Subject: Structural Assessment
45 Viola Lane
Angier, NC 27501

Seven Lakes Engineering Services, Inc. (SLES) performed an inspection on July 13, 2020. The purpose of the inspection was to provide data to assess the 20'x35' storage building that was added to the subject site.

**JOIST LAYOUT**

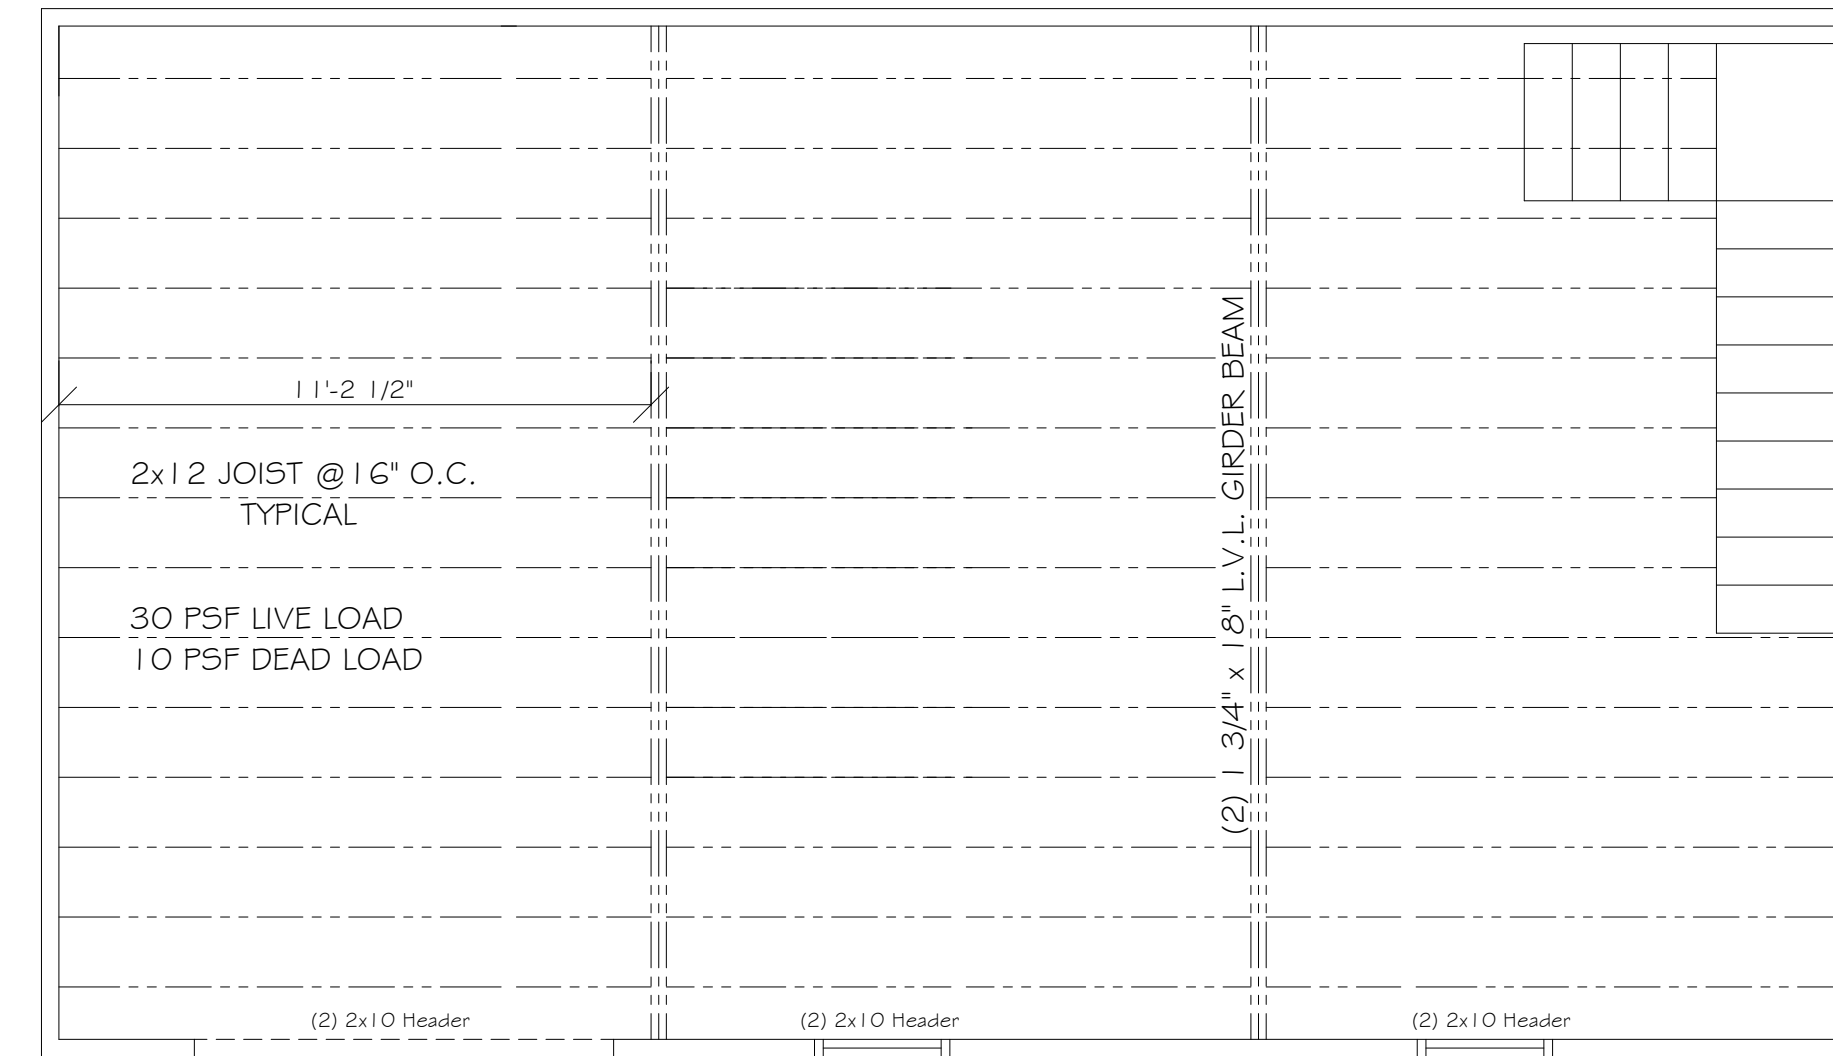
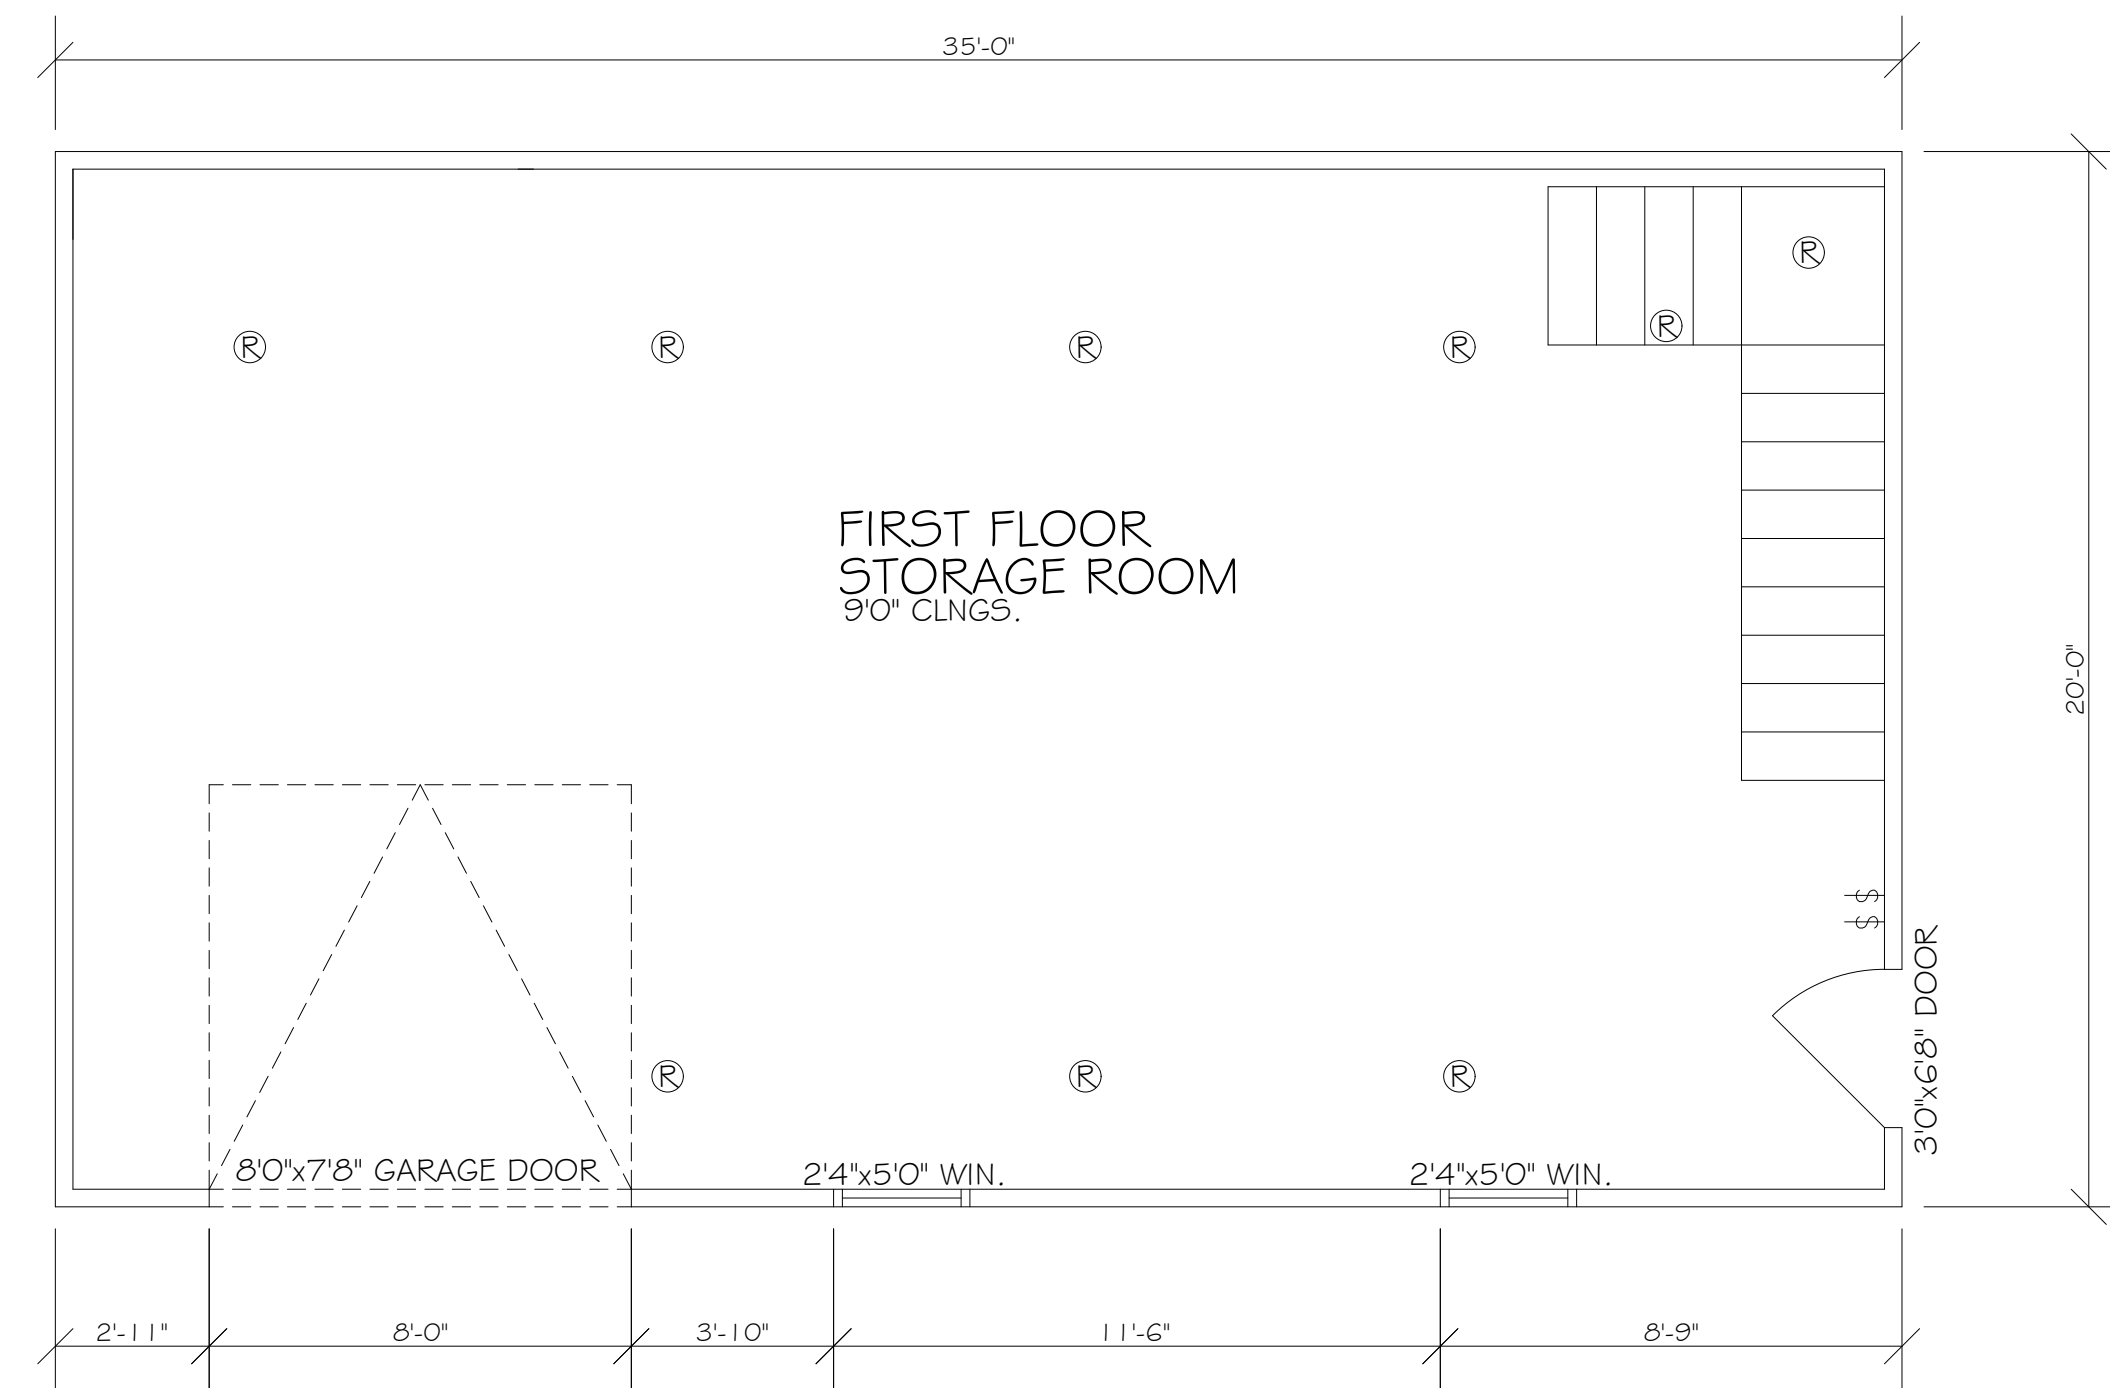
Upon inspection of the subject building, SLES did not note any abnormalities with the construction of the subject building. Upon analysis of the floor system, SLES has determined the subject floor system of the building is operating at 80% capacity. Upon visual inspection of the roof system of the subject building, SLES did not note any abnormalities. The roof system is a stick built roof system with 2x8 rafters, 2x8 ridge beam and 2x4 collar ties. The collar ties for the roof system are located within the upper 1/3 of the attic. Upon inspection of the wall frame construction, SLES did not note any abnormalities with the construction of the exterior load bearing walls. The proper anchor bolts were used to attach the exterior walls to the concrete slab foundation of the subject building.

**FIRST FLOOR PLAN**

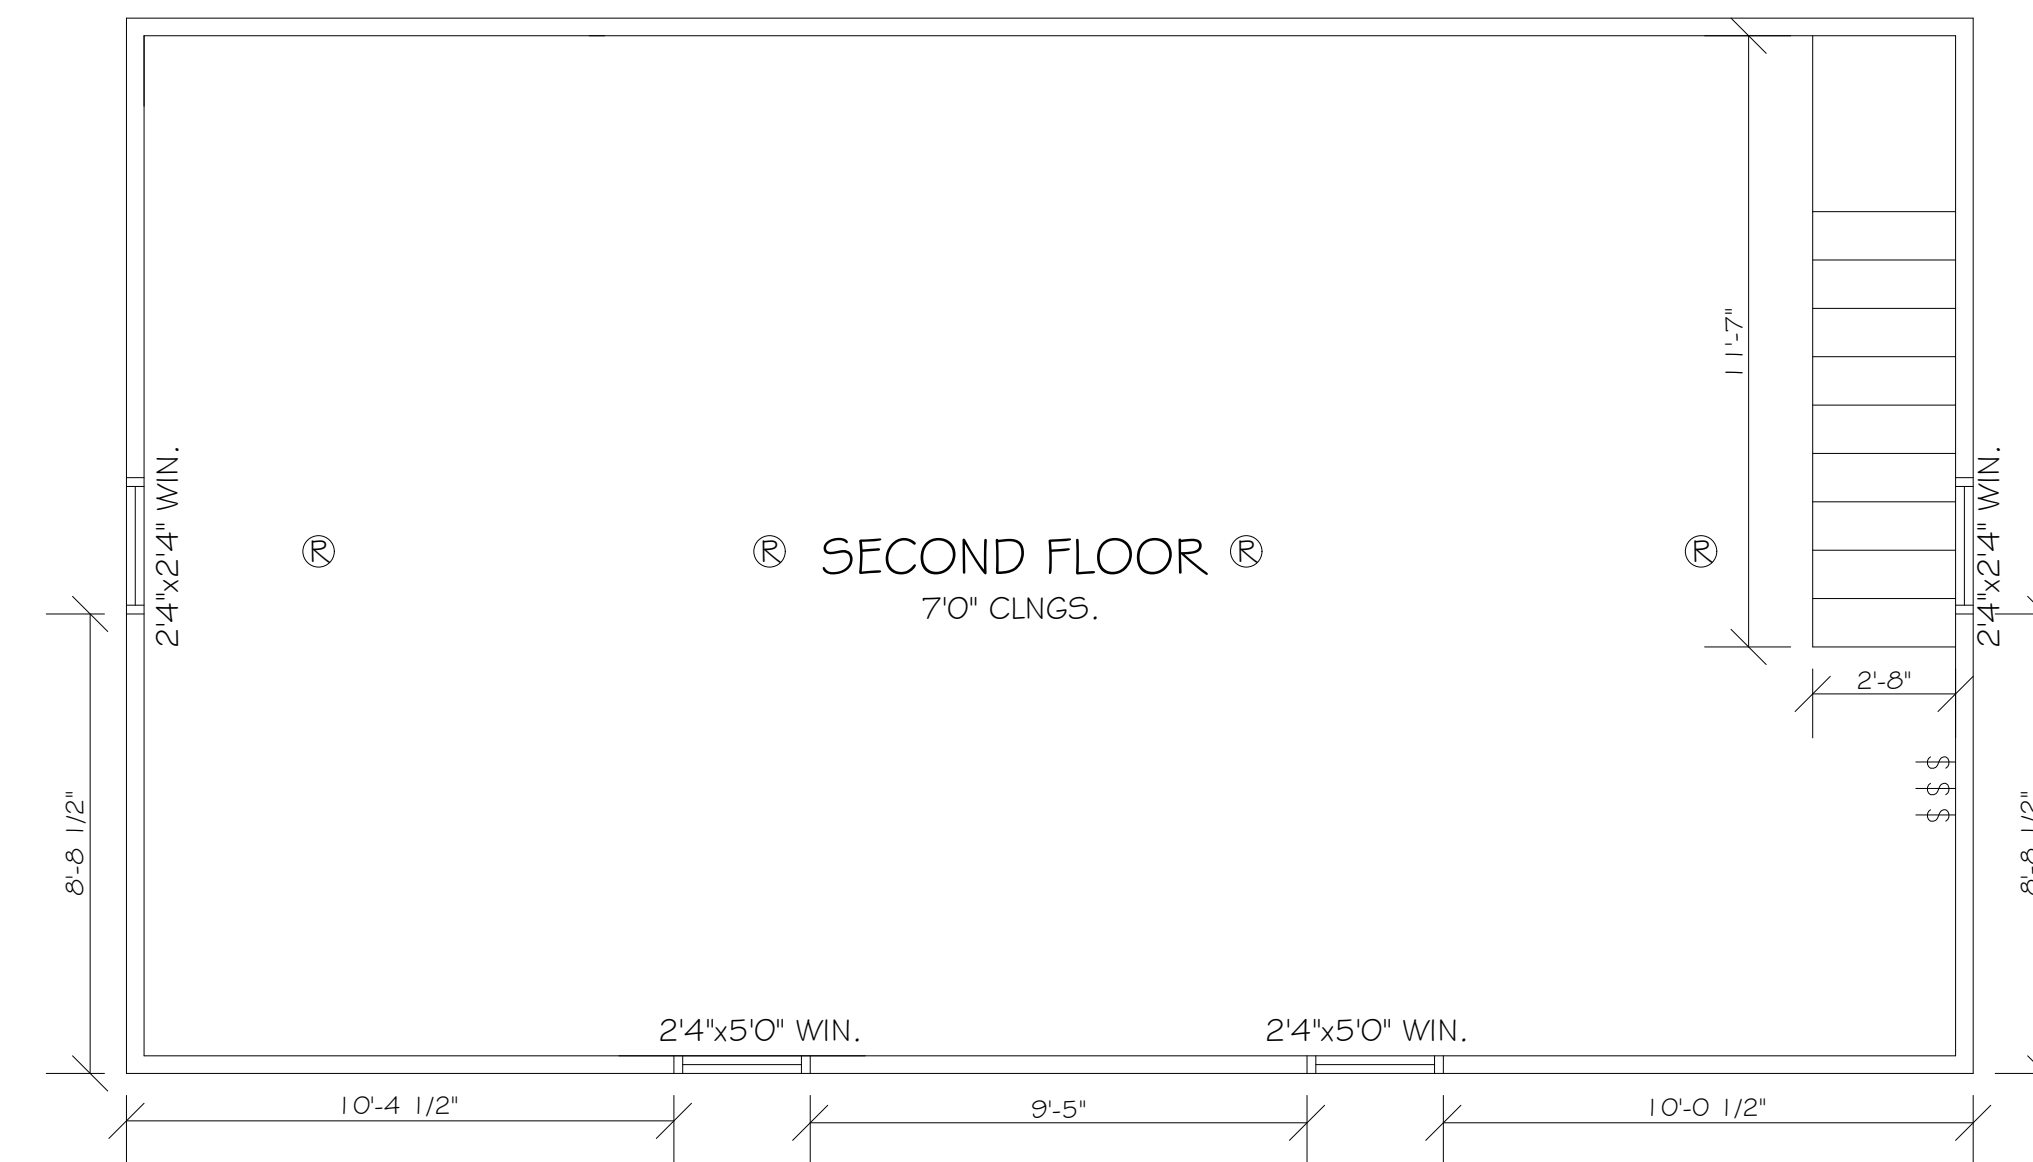
Upon further investigation, SLES recommends that a licensed electrical contractor be contacted to provide an inspection of the electrical services of the subject building. The spacing of the receptacles in the subject building must be in compliance with the 2018 NEC section 210.52.A1, "Receptacles shall be installed so that no point measured horizontally along the floor line of any wall space is more than six feet from a receptacle outlet."
